# Preferred Project & Response to Submissions Report

## Section 75W Modification Major Project MP08\_0211 (MOD 3)

23-41 Lindfield Avenue, 7 and 11 Havilah Lane

Mixed Use Development

3 2B TYPE B - PRE_ADAPTATION (105B,108B,205B,208B,305B,308B)
6001 SCALE 1 : 50

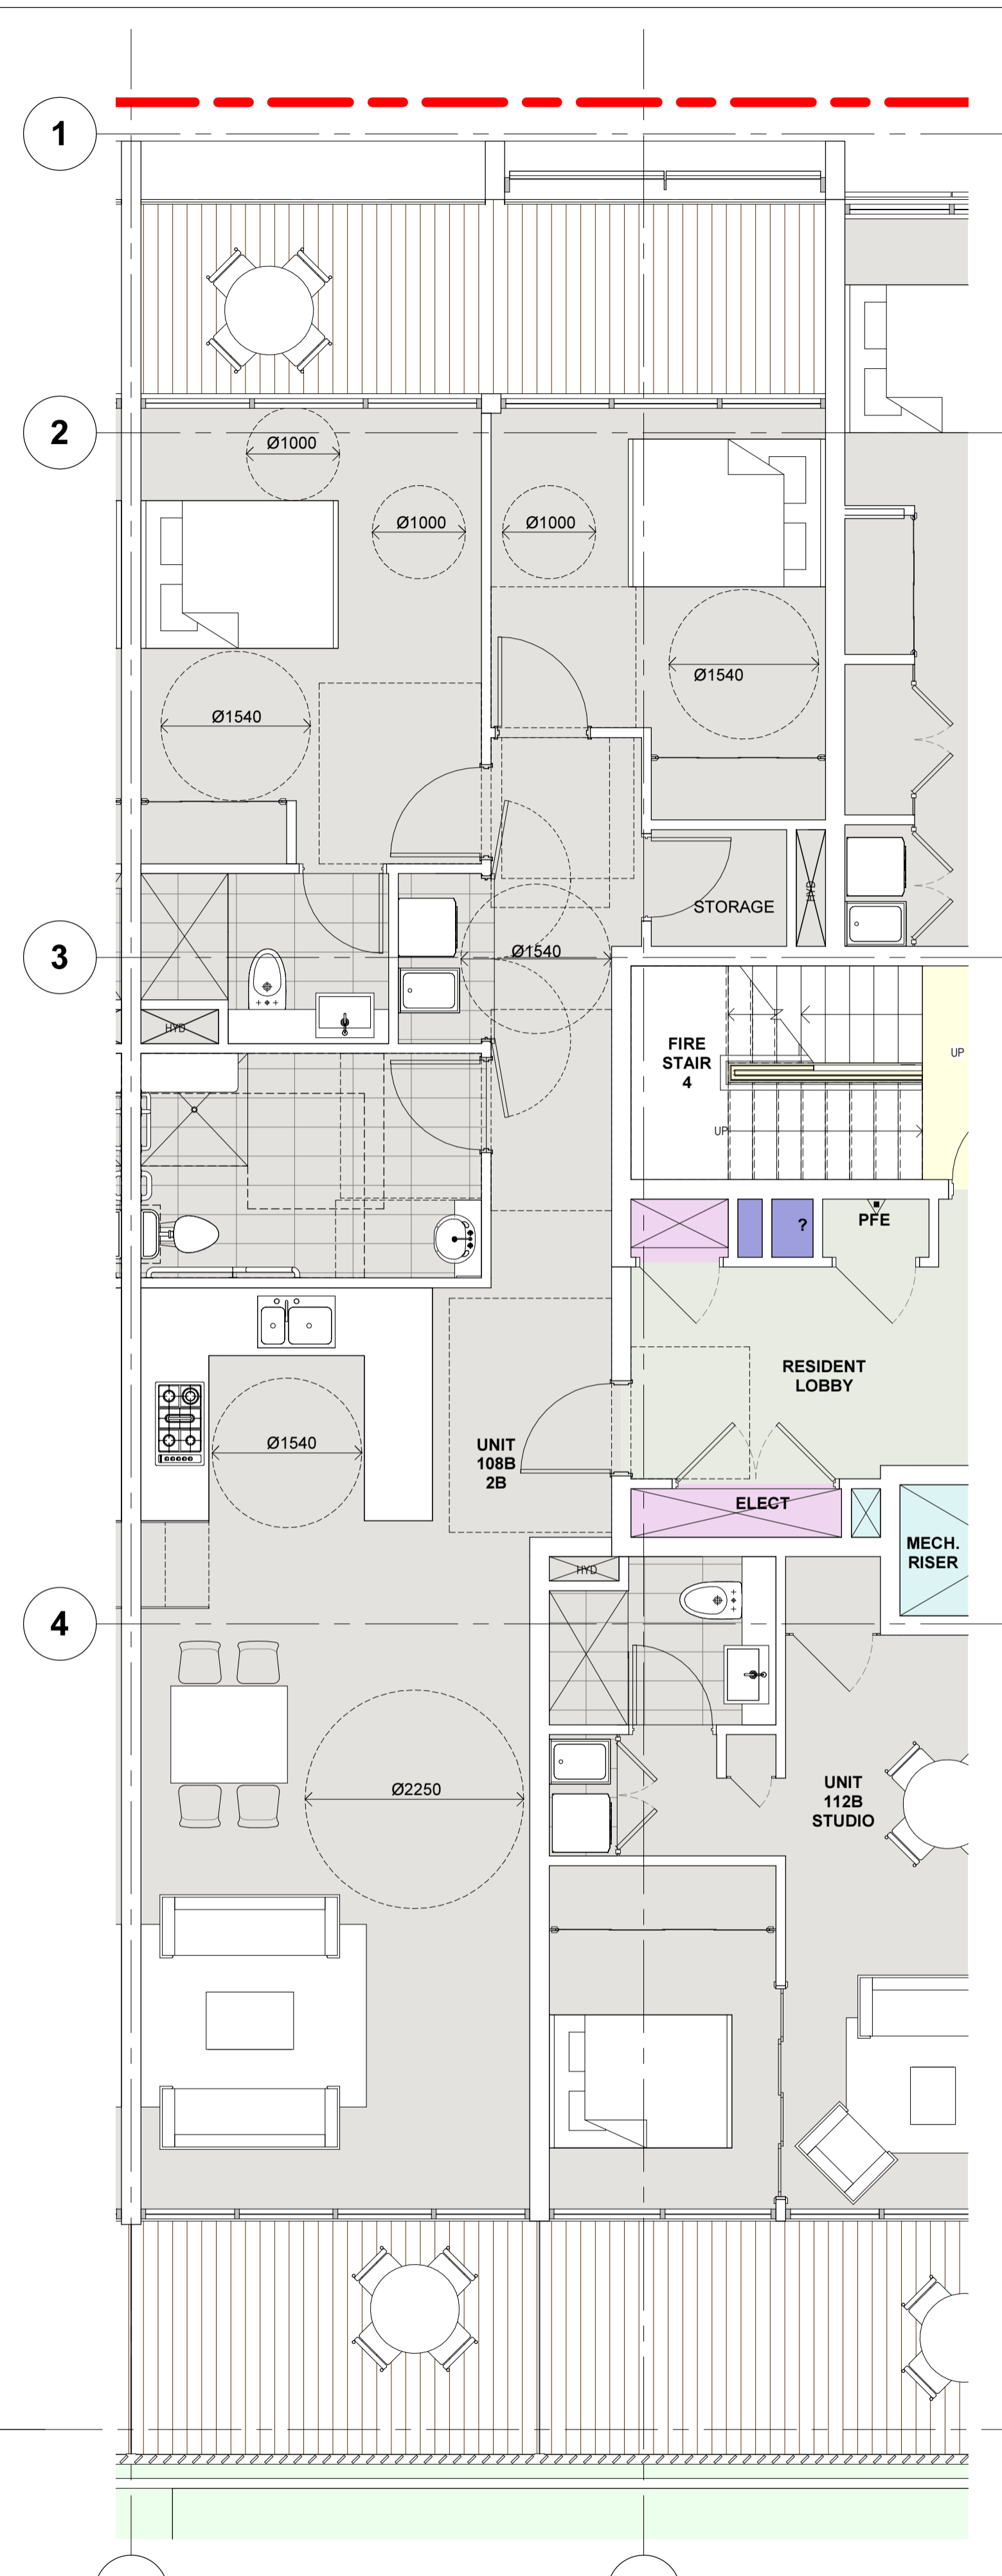
| Adaptable Apartments            | The Adaptation Detail Plans, Drawing No 6001 shows that the accessible bathroom in the 2B type B adaptable apartments does not have an AS 1428.1 compliant shower recess at pre-adaptation stage. In addition the adaptable apartments do not meet the requirements of AS4299. It is recommended that the apartment layouts be revised to address the issues raised.  | <ul style="list-style-type: none"> <li>A revised Adaptation Details plan is provided with the revised architectural drawings at <b>Appendix A</b>.</li> </ul>  |
